**OXFORDSHIRE COUNTY COUNCIL’S RESPONSE TO CONSULTATION
ON THE FOLLOWING DEVELOPMENT PROPOSAL**

Application no: 21/03268/OUT

Proposal: Outline planning permission (all matters reserved except for access) for the erection of buildings comprising logistics (Use Class B8) and ancillary Office (Use Class E(g)(i)) floorspace; construction of new site access from the B4100; creation of internal roads and access routes; hard and soft landscaping including noise attenuation measures; and other associated infrastructure

Response date: 28 April 2022

Section 1-1 (1:250 @A1)

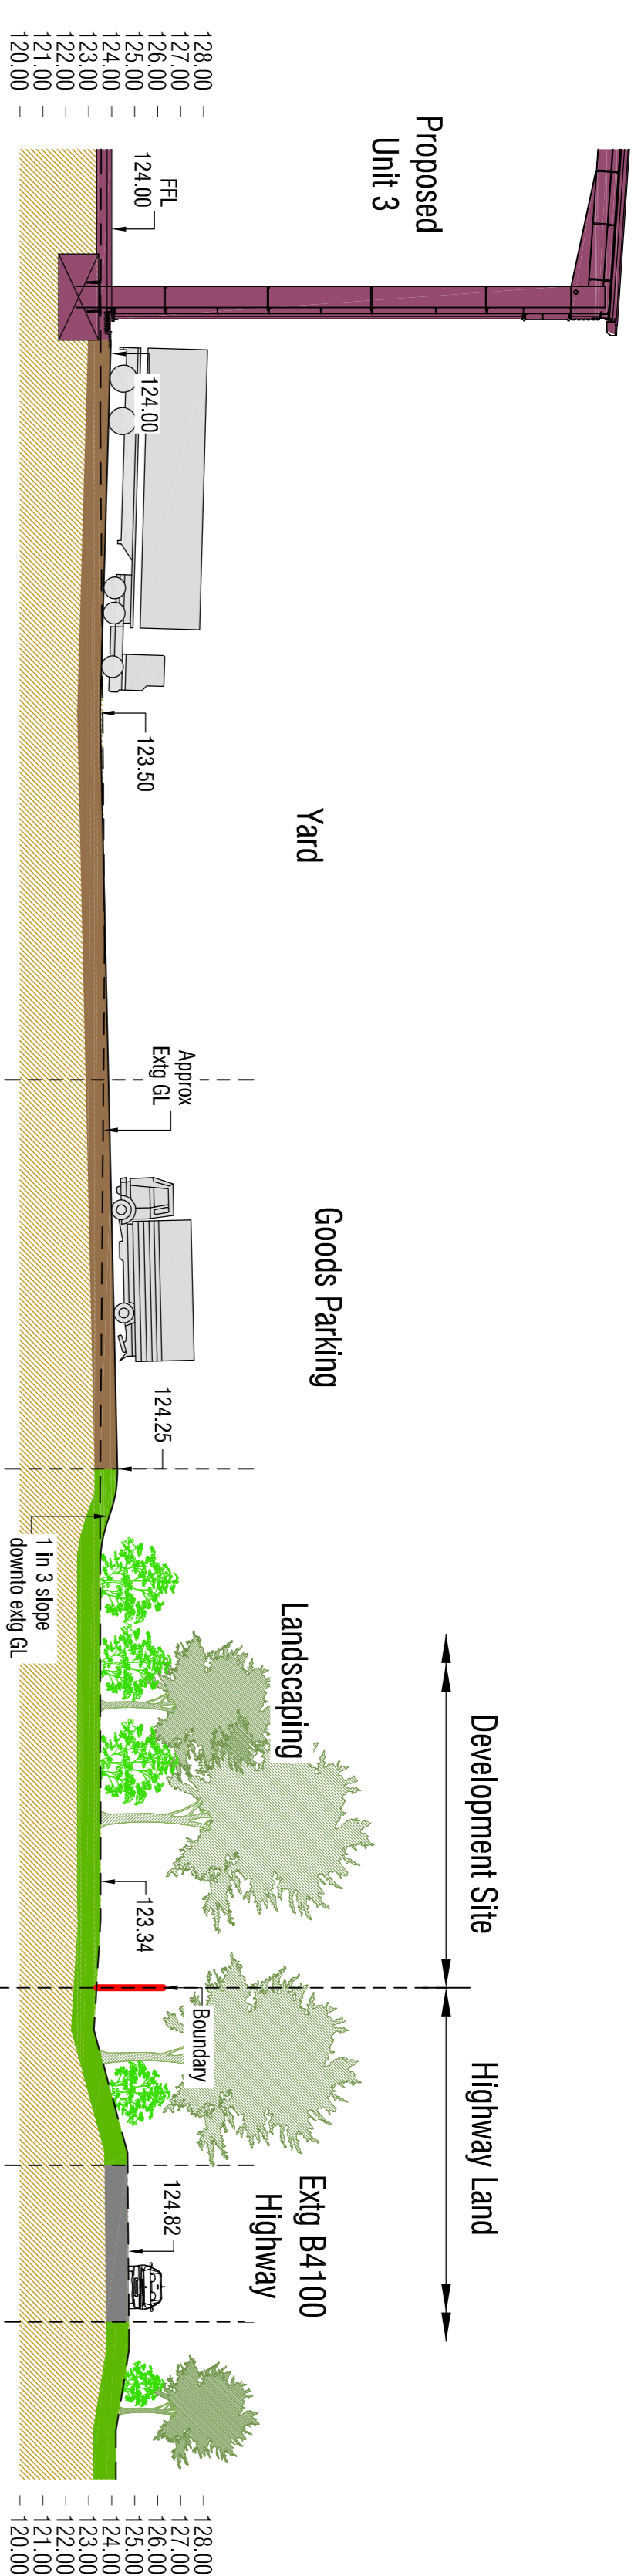
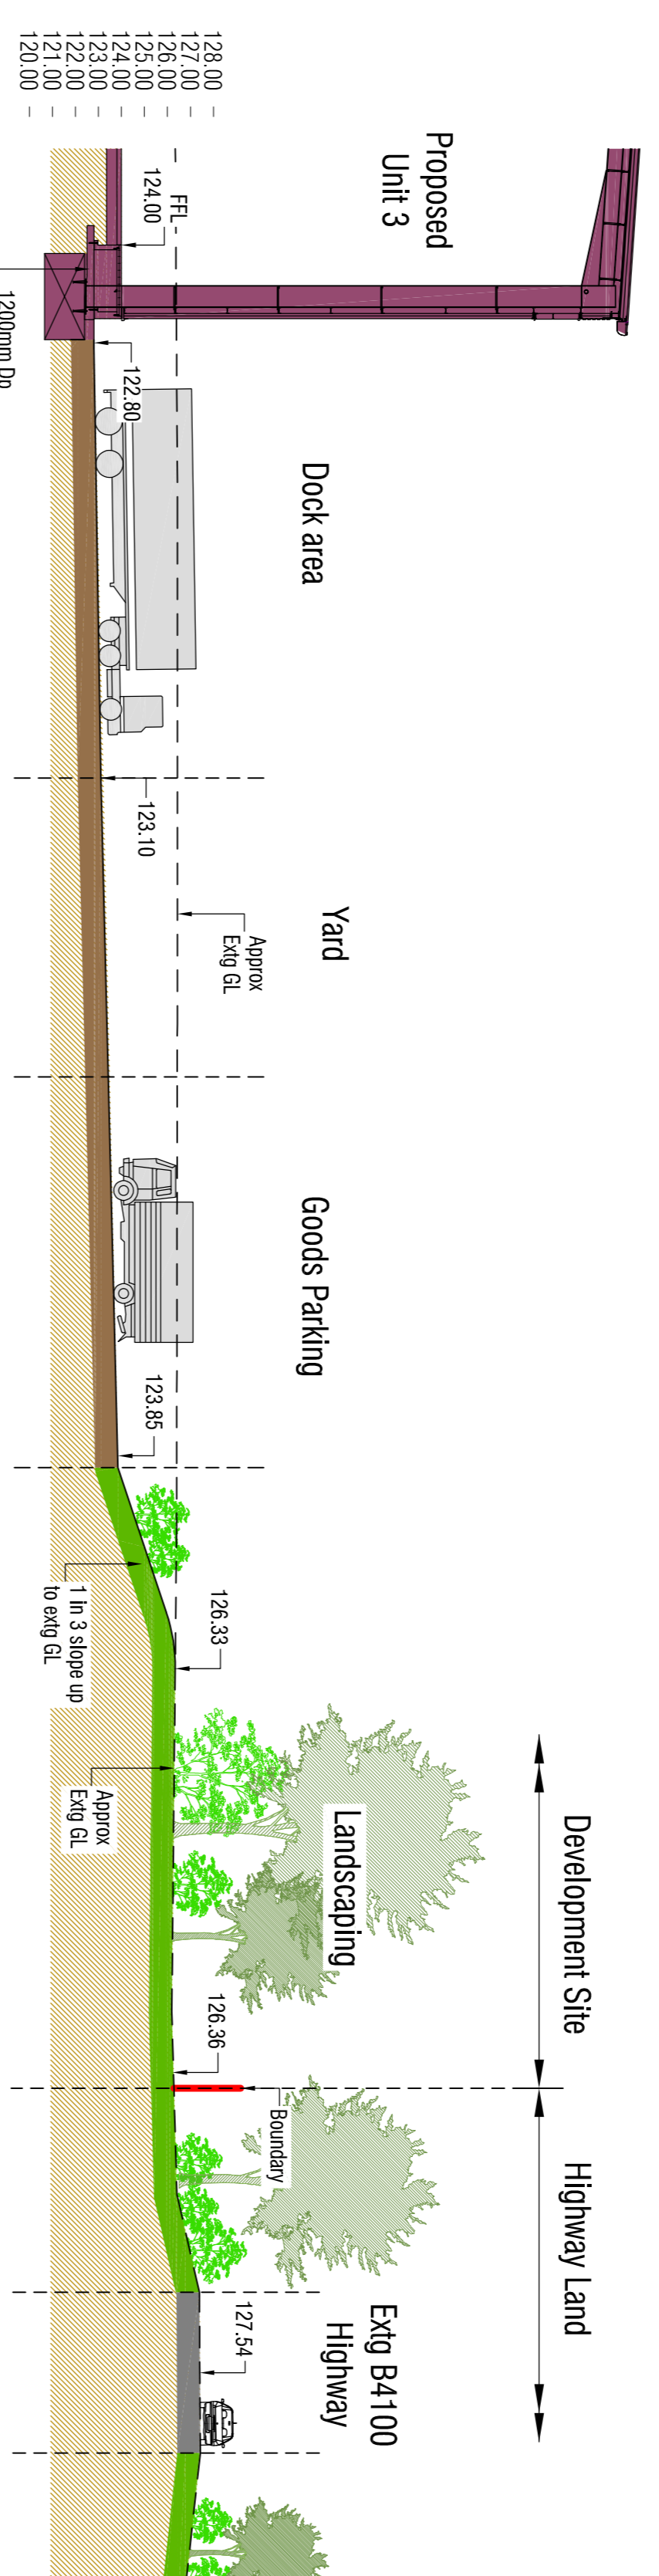
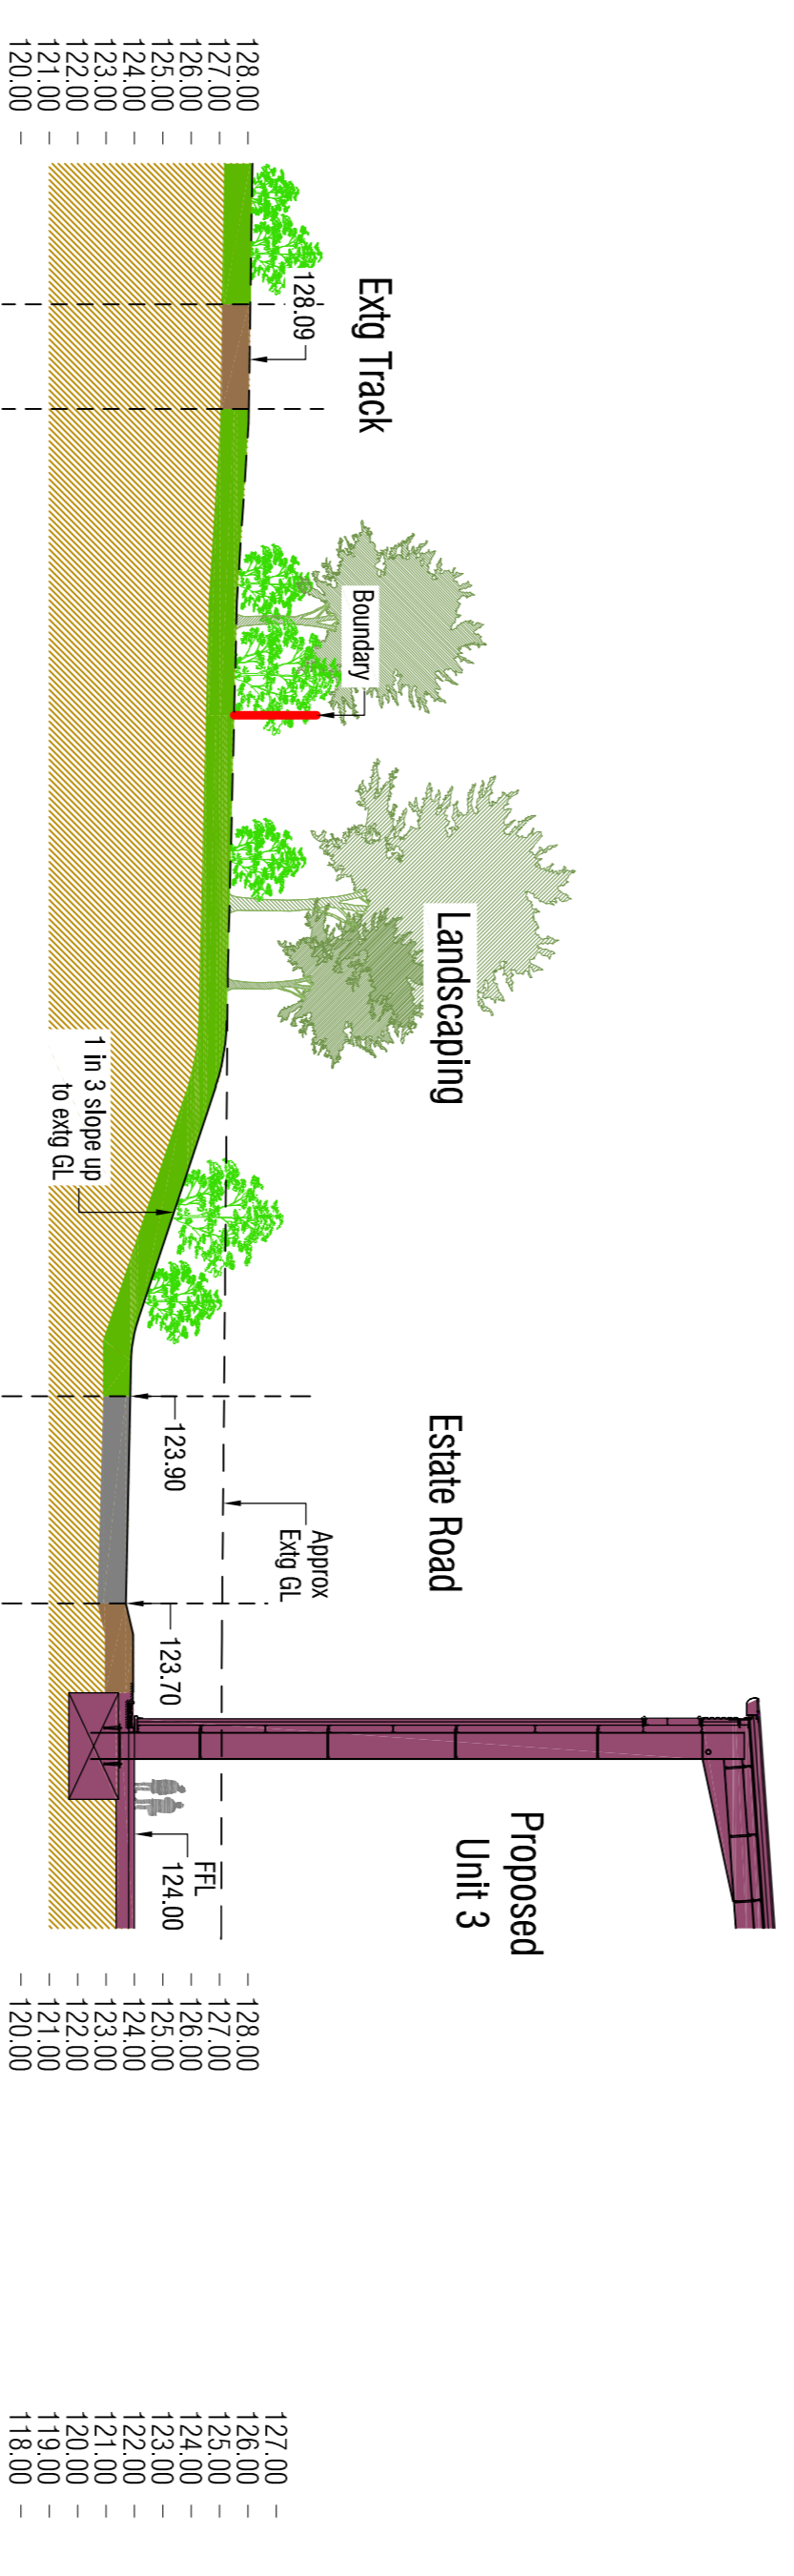
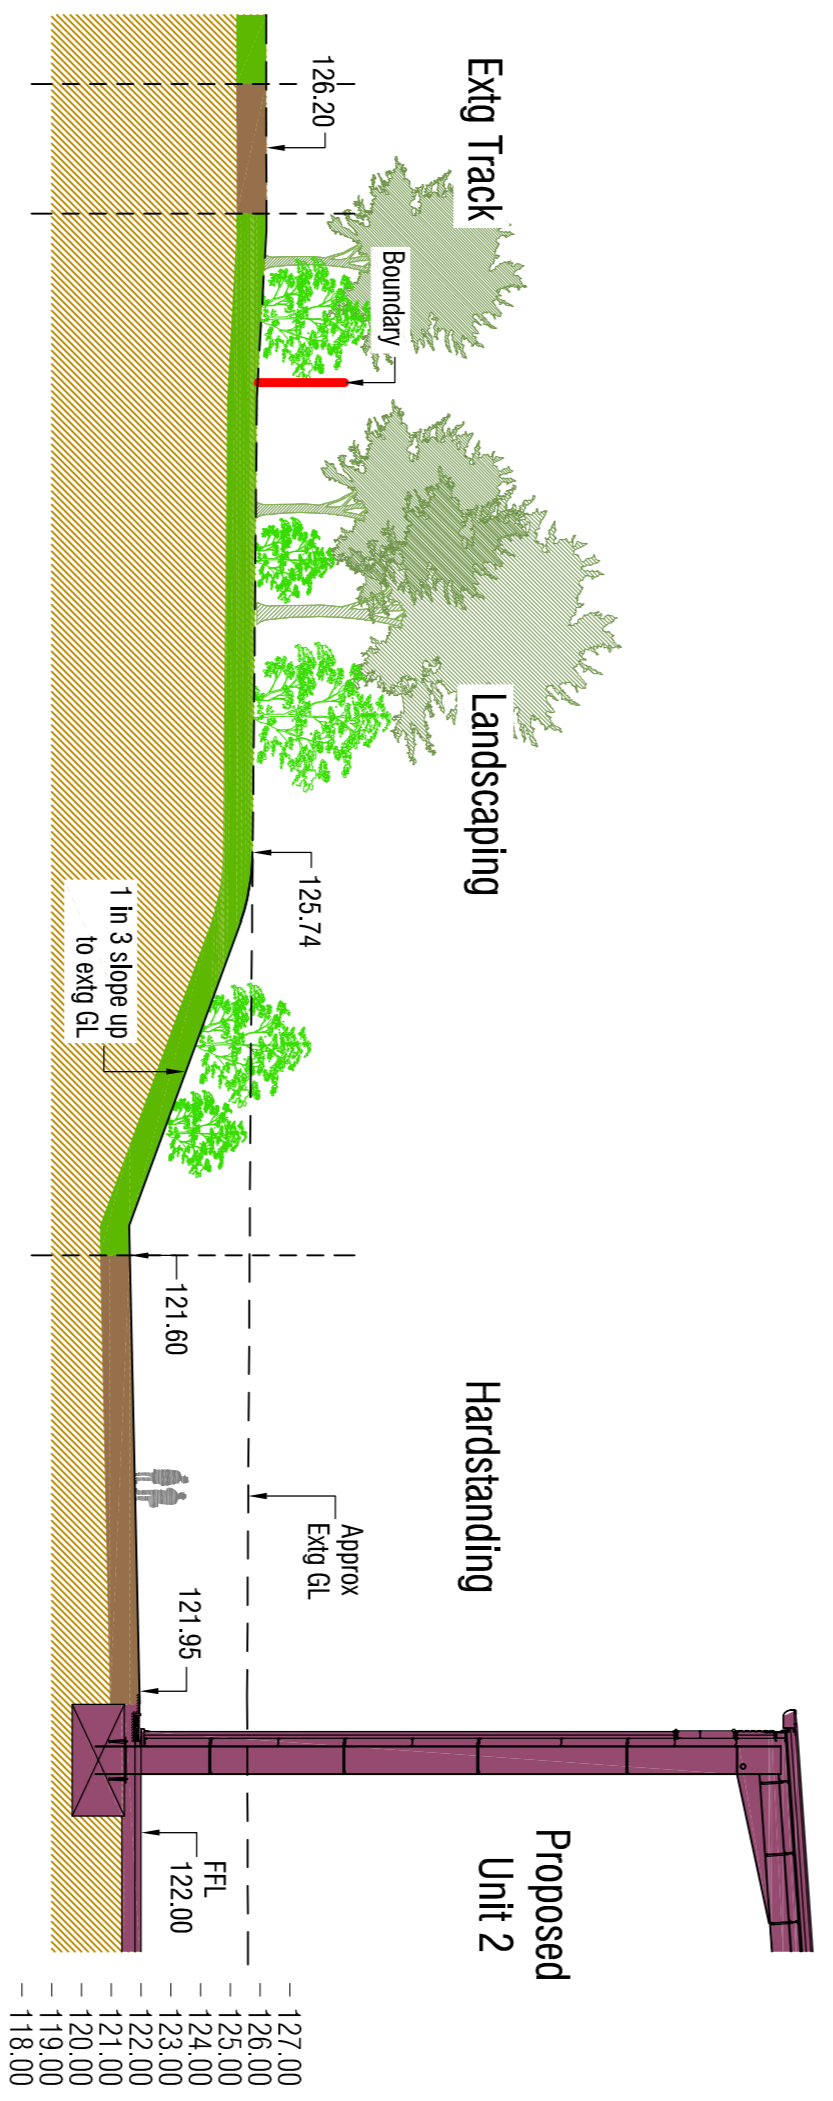
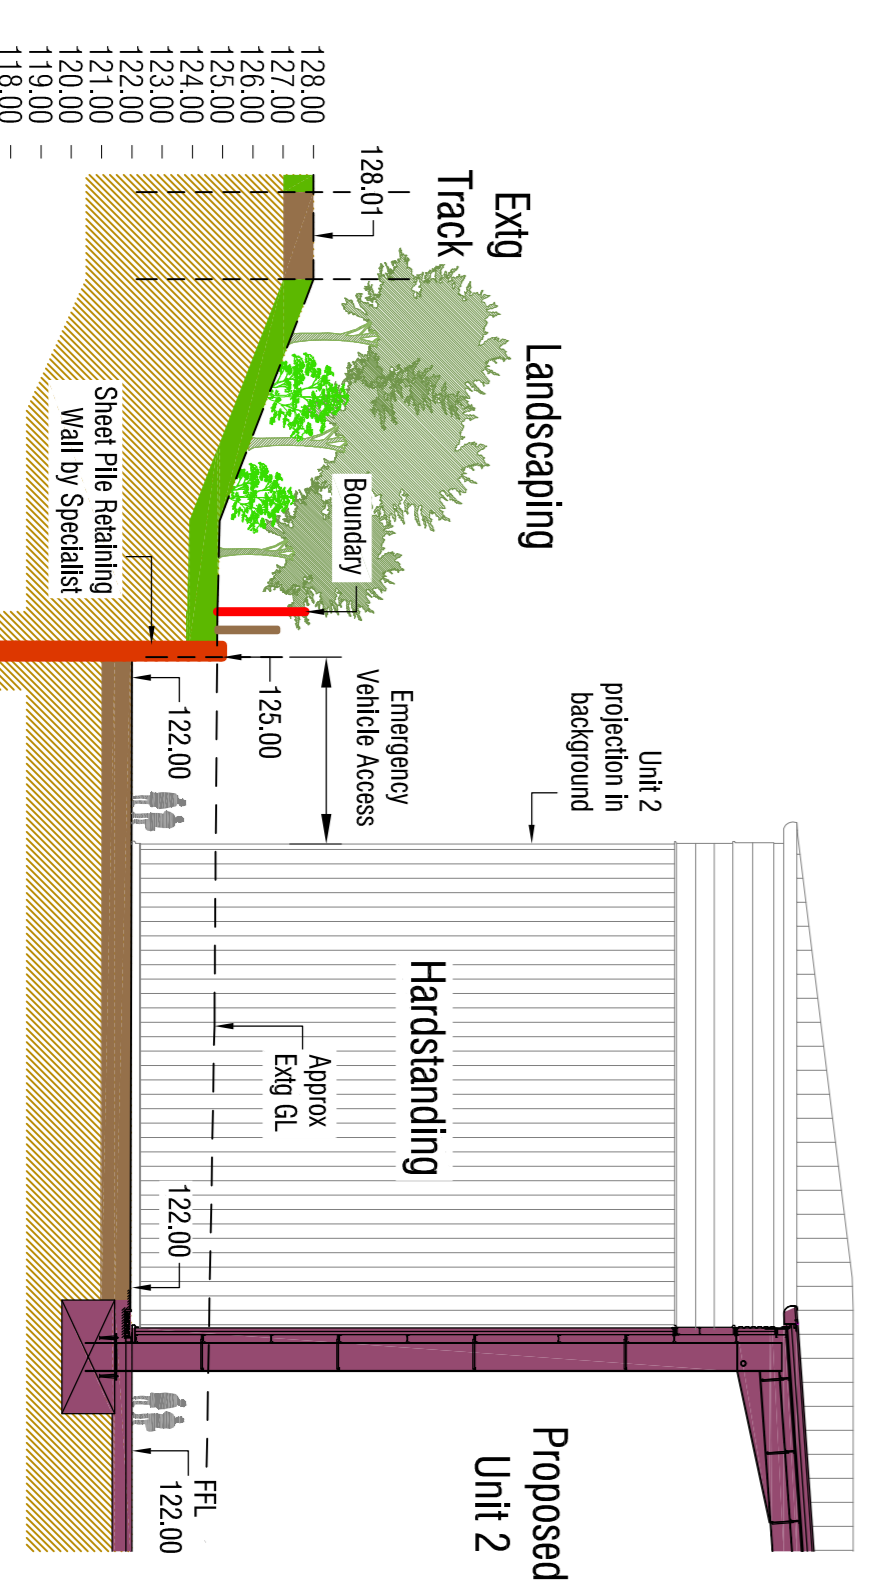
The further information also includes proposed cross sections which include alterations to the public highway. The Highway Authority reserves its position on these, pending agreement of the proposed highway arrangements, which are not approved (please see our previous consultation response).
